From: Hannah Curry [REDACTED]
Sent: 04 January 2021 12:01
To: Simon Davis; Nicola Moore
Cc: Daniel Medrow; Planning.Responses
Subject: RE: Land off Burndell Road, Yapton - Y/98/18/RES & Y/97/18/DOC
Attachments: Condition 5 6.pdf

Subject: Land off Burndell Road, Yapton - Y/98/18/RES & Y/97/18/DOC

Drawing Title
**ADOPTABLE DRAINAGE
CONSTRUCTION DETAILS 2 OF 2**

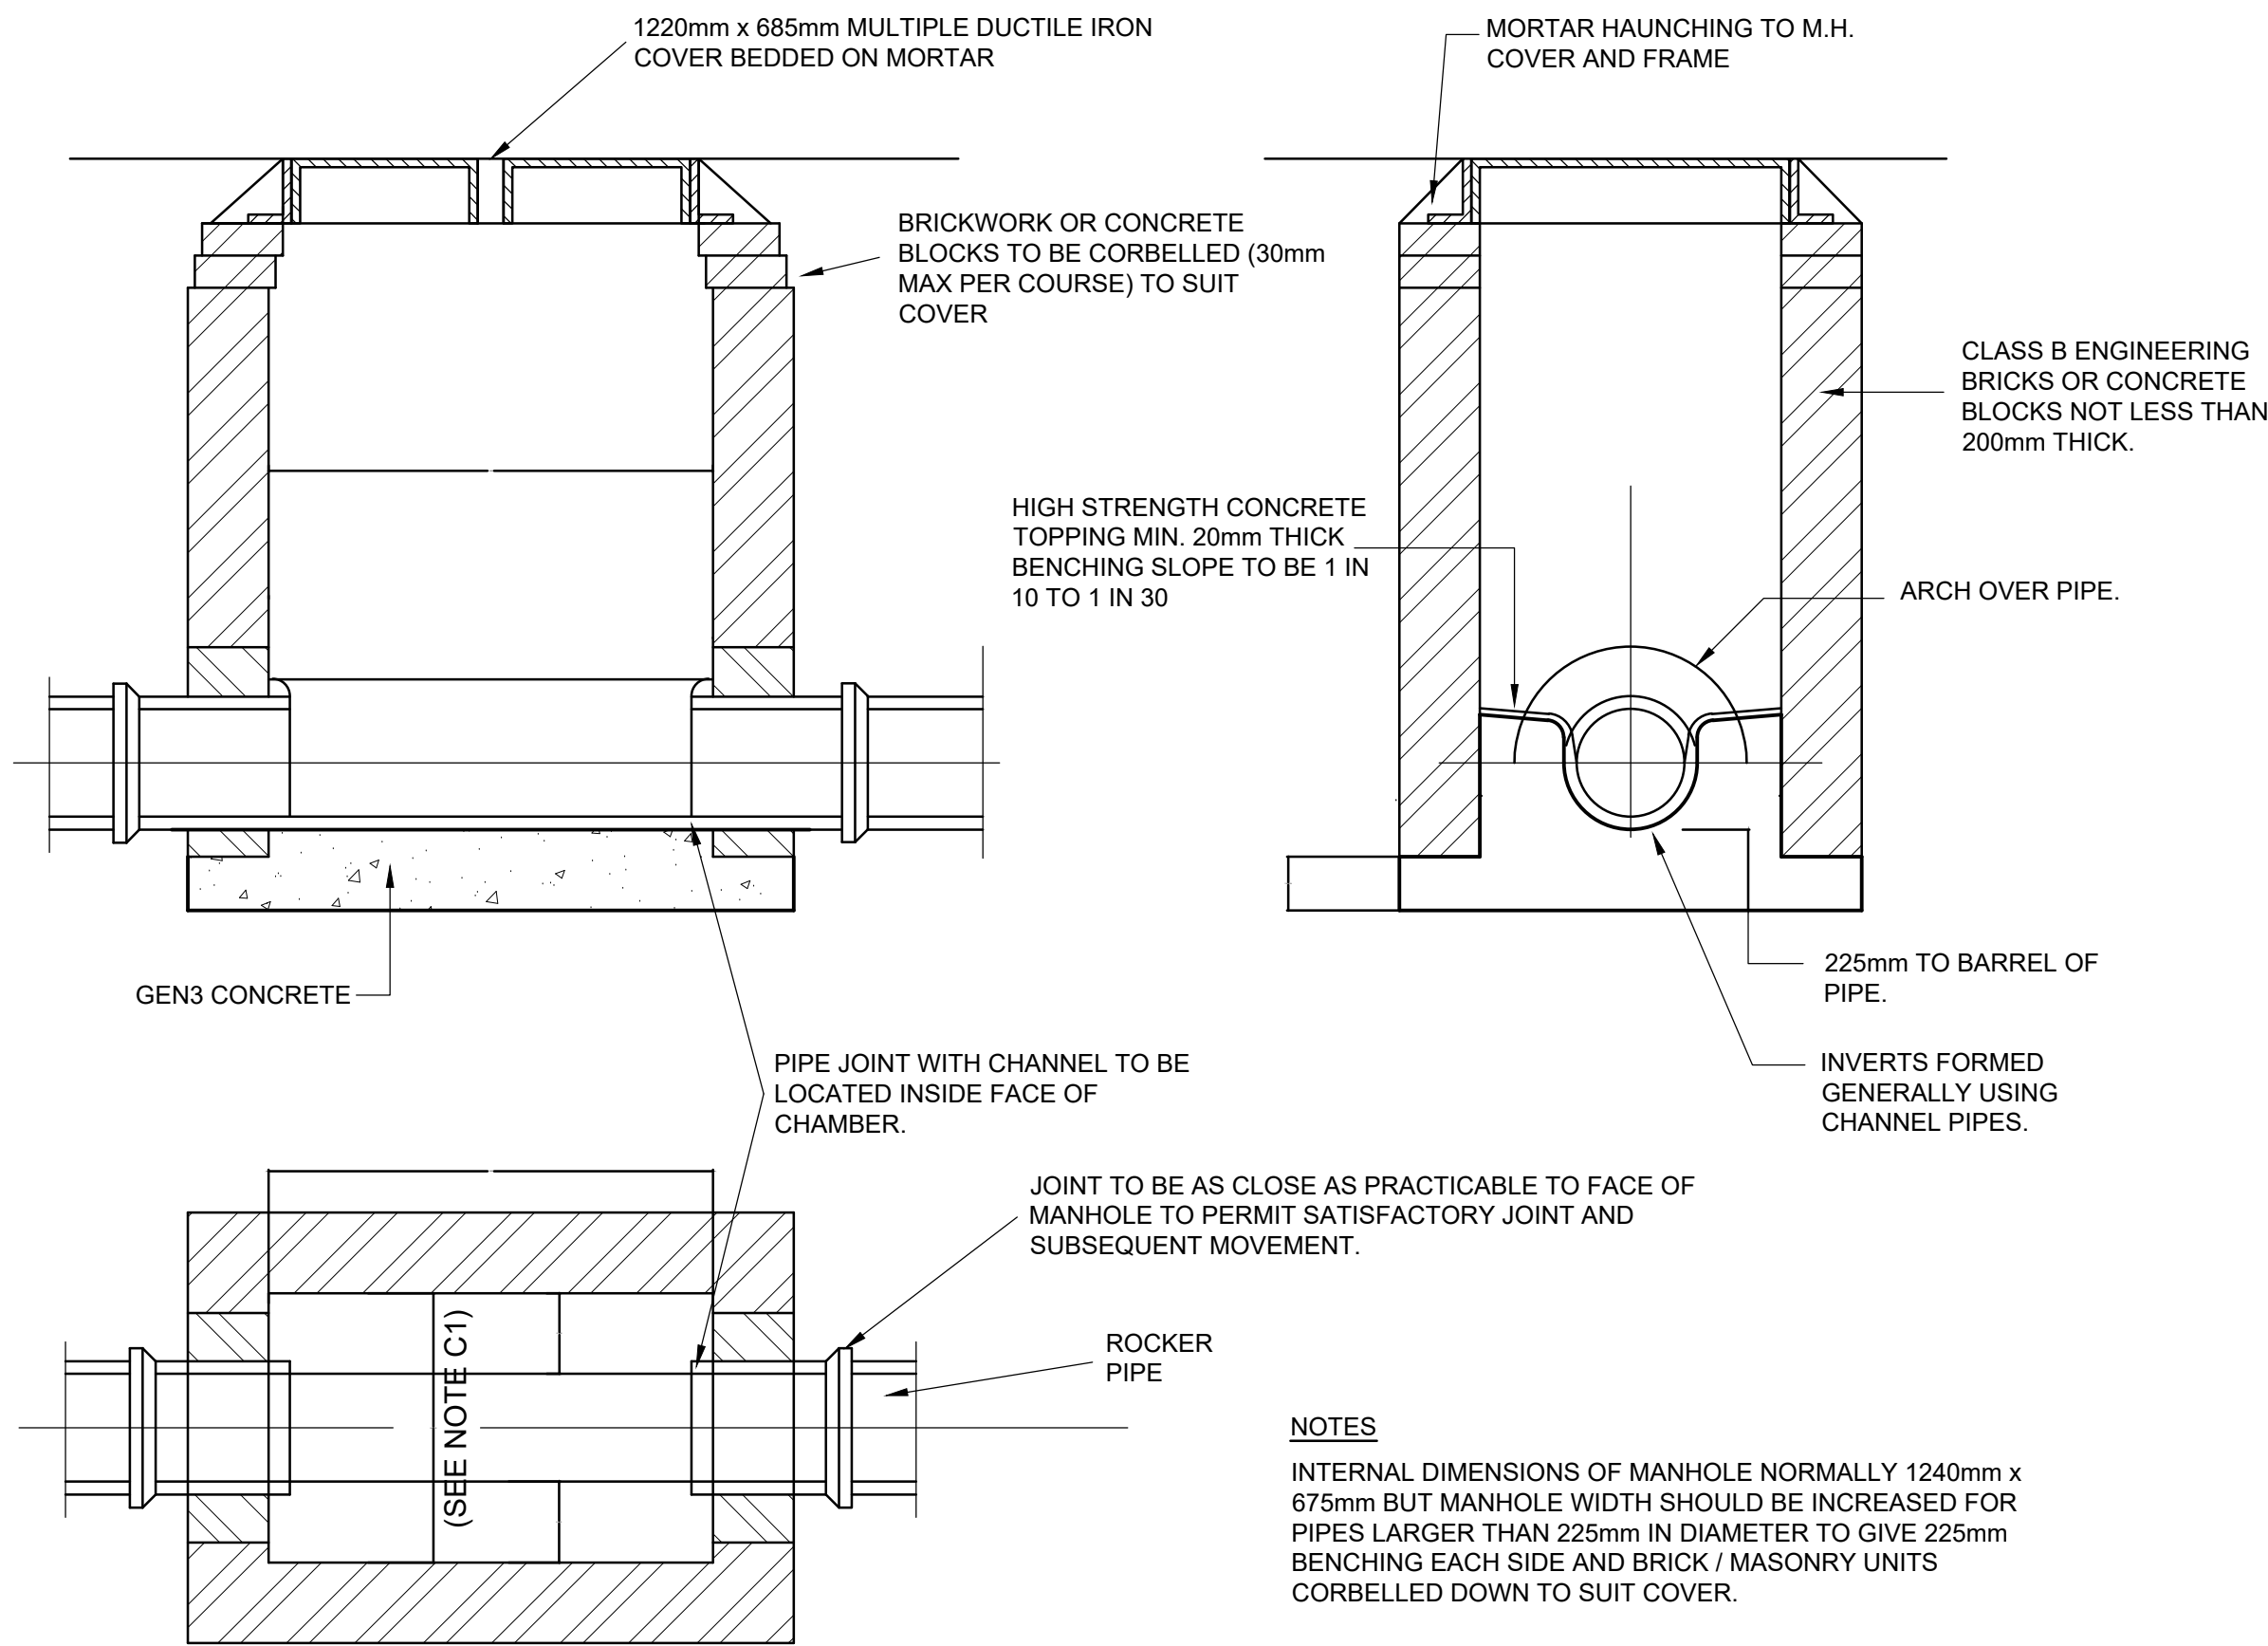
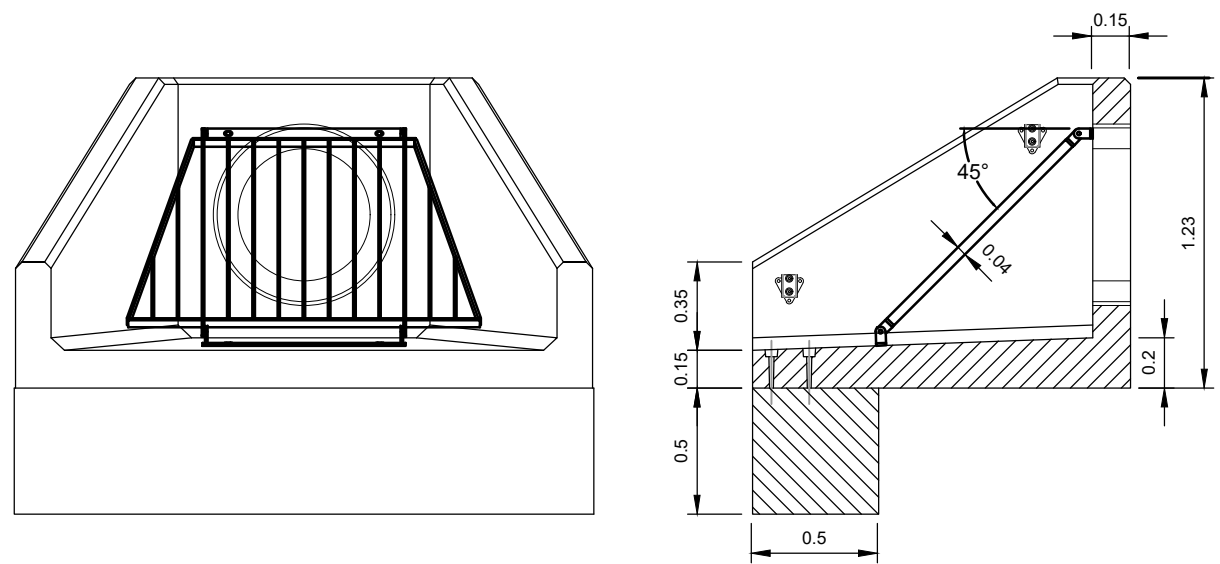
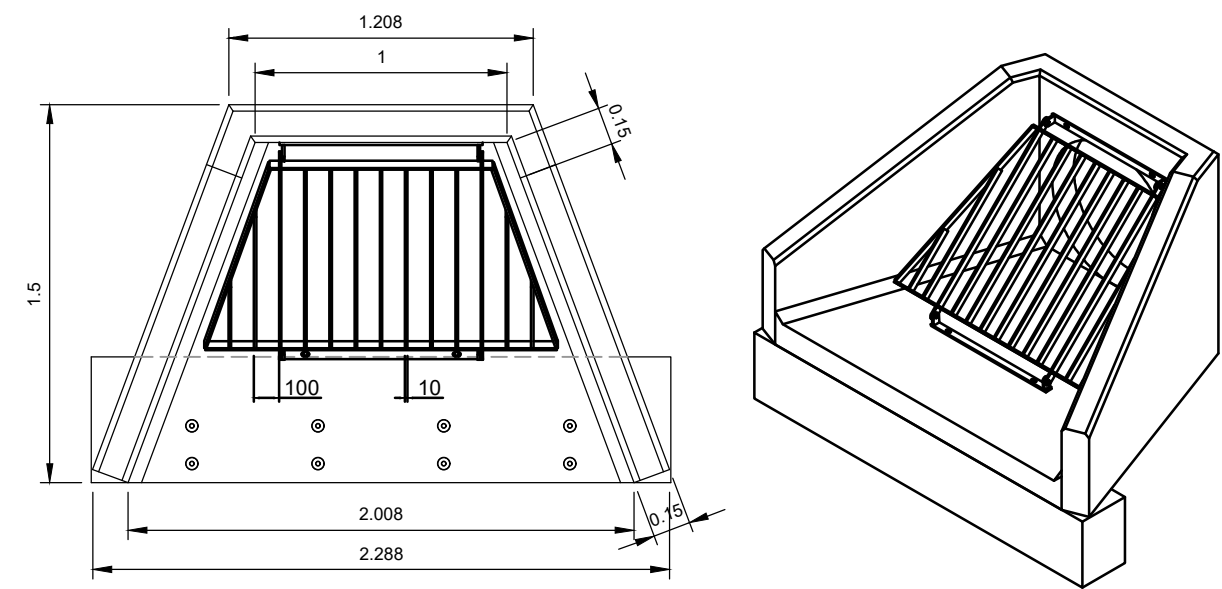
It has just been brought to my attention that some form of chamber has been added to the surface water drainage system on the eastern side of the site (on the surface water drain just south of plot 18 between the road and the headwall into the ditch). I note that this chamber is not on the approved plans so I wanted to check that it will be on the new submission.
